June 20, 2021

Subject: The Ashville House Plan  
Harnett County

I reviewed the construction drawings and the truss and beam designs furnished by Comtech. Comtech also provided the reaction loads.

1 Truss Placement Plan
Scale: 1/4"=1'

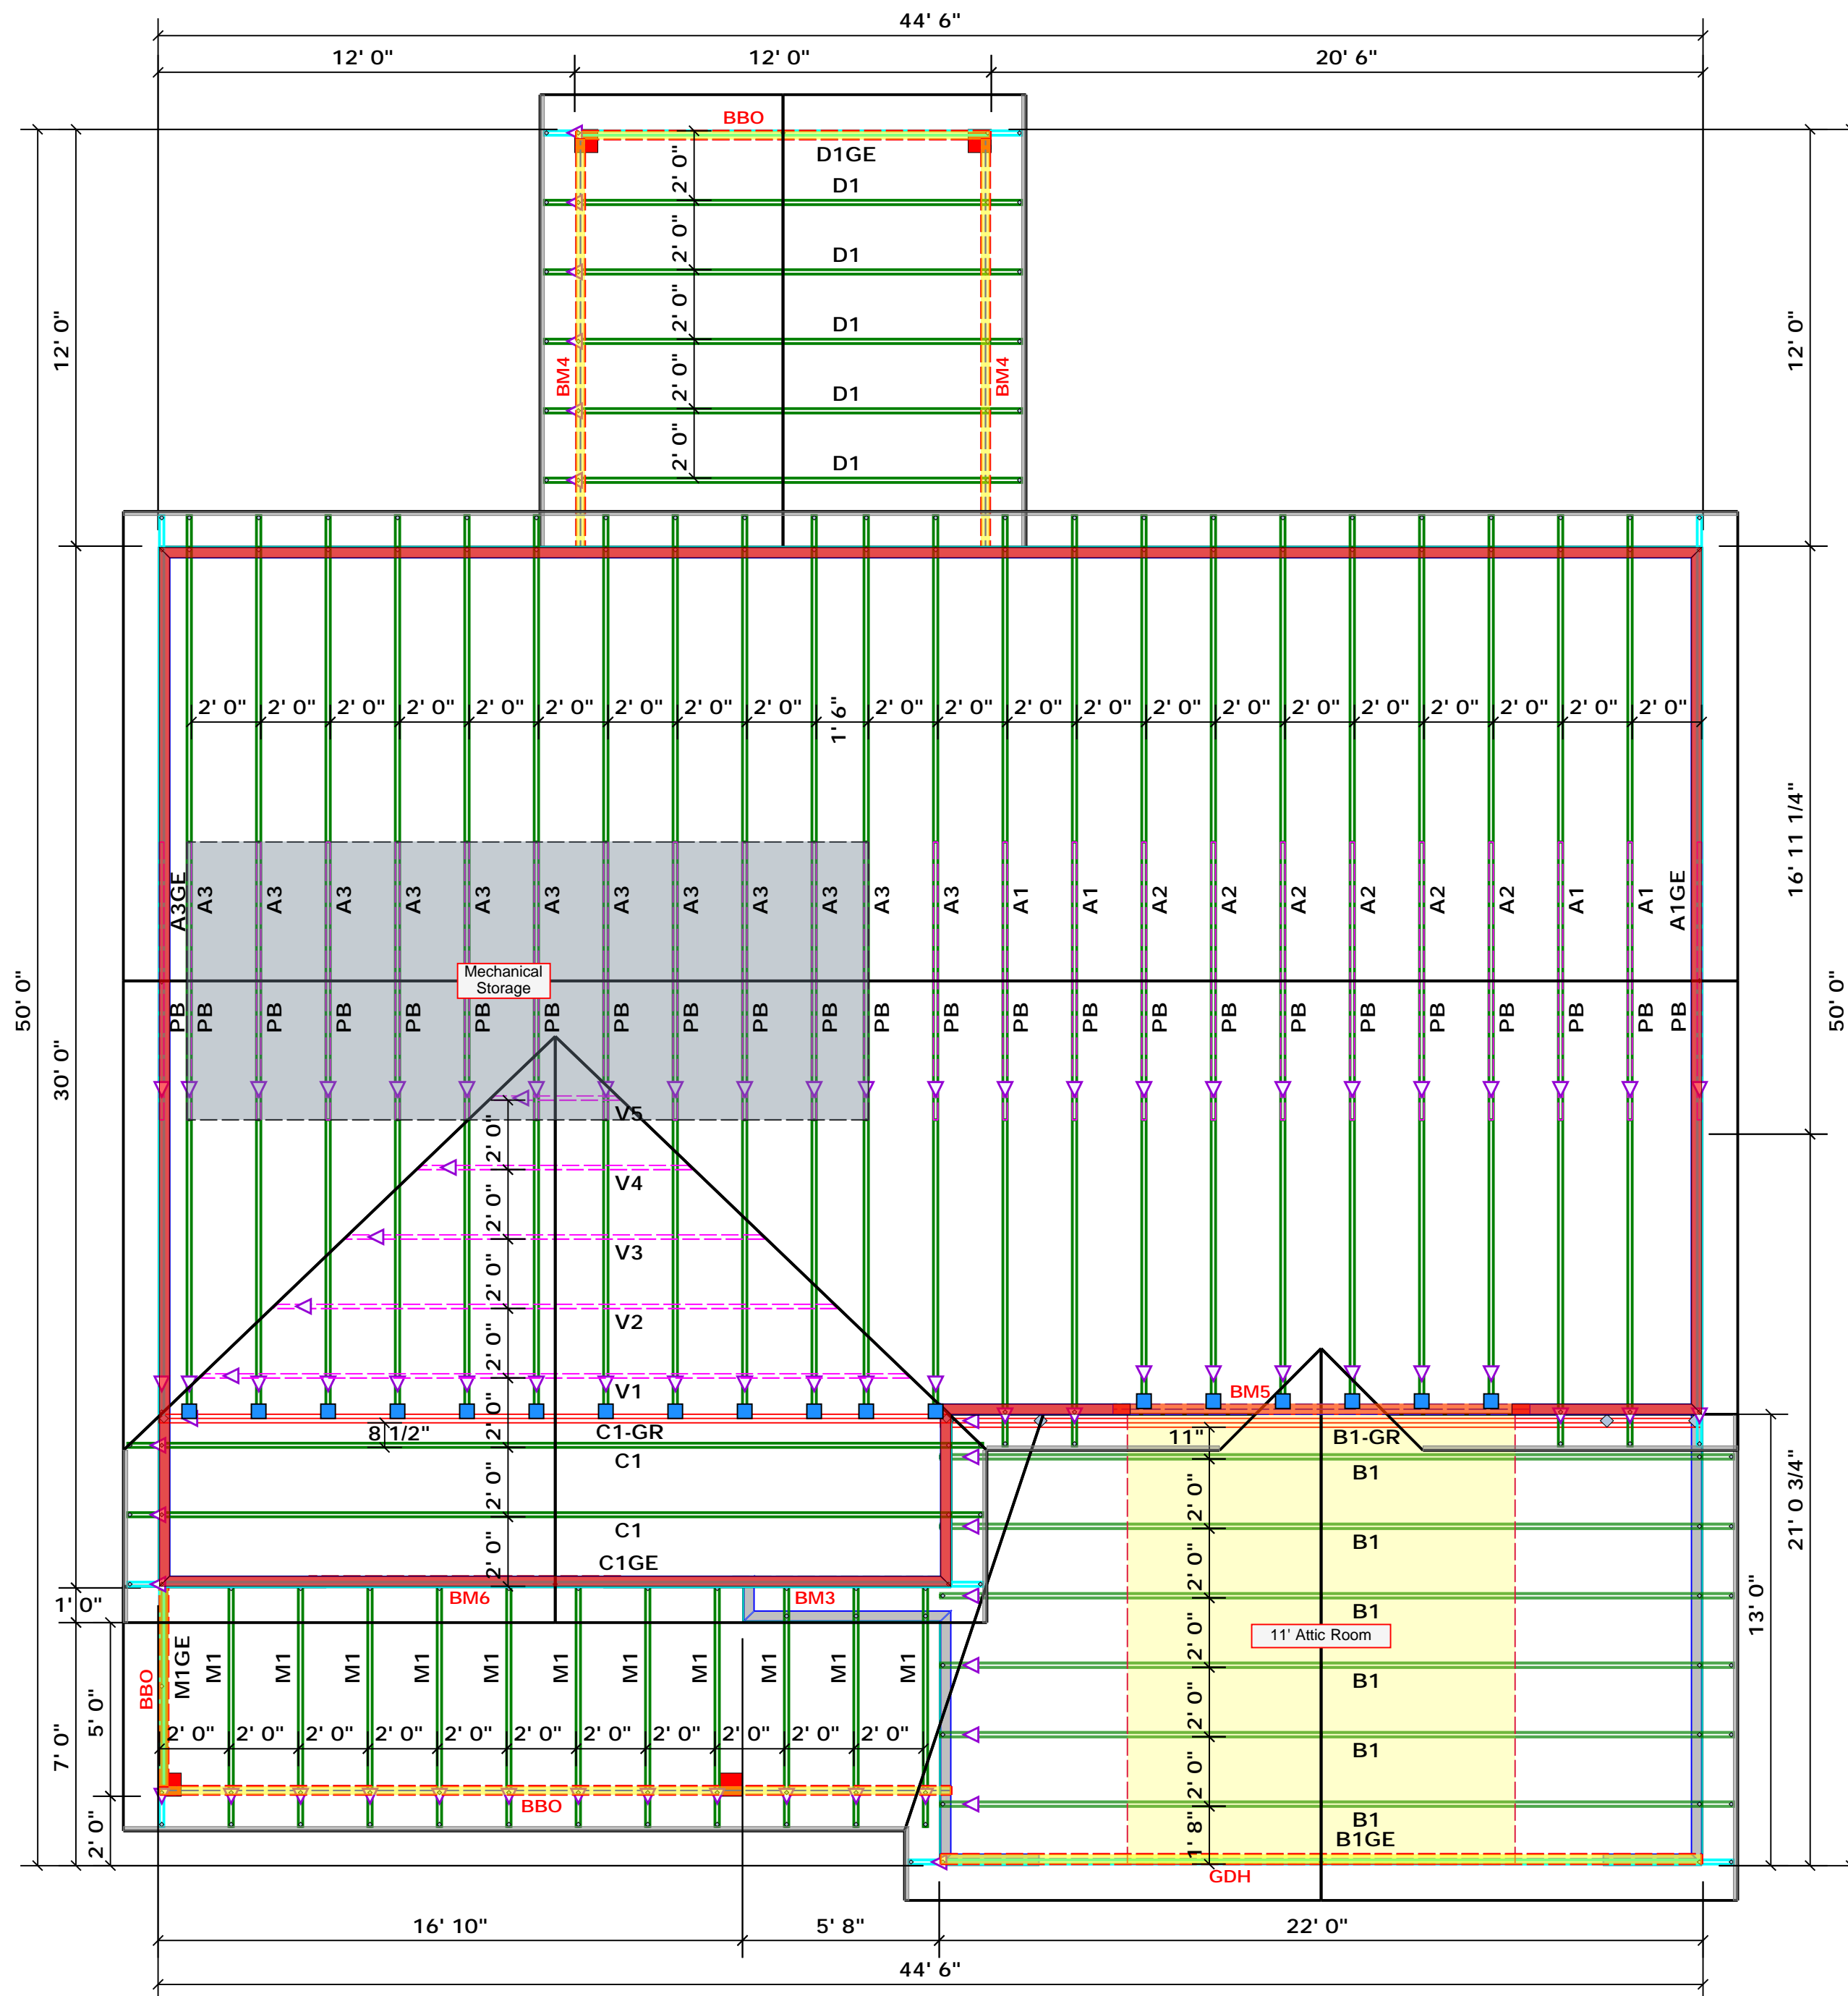
At the junction where trusses C1GR and B1GR meet, there is a significant load being transferred to the footing below. However, the 36" x 36" x 8" footing will support the load.

Truss C1GR is a two-ply, and truss B1GR is a three-ply truss. Fasten the truss members together according to the note on the truss design sheets.

Both trusses require larger support columns. Follow the dimensions on the truss drawings and install the correct number of studs. Fasten the studs together with two rows of 10d nails in each stud.
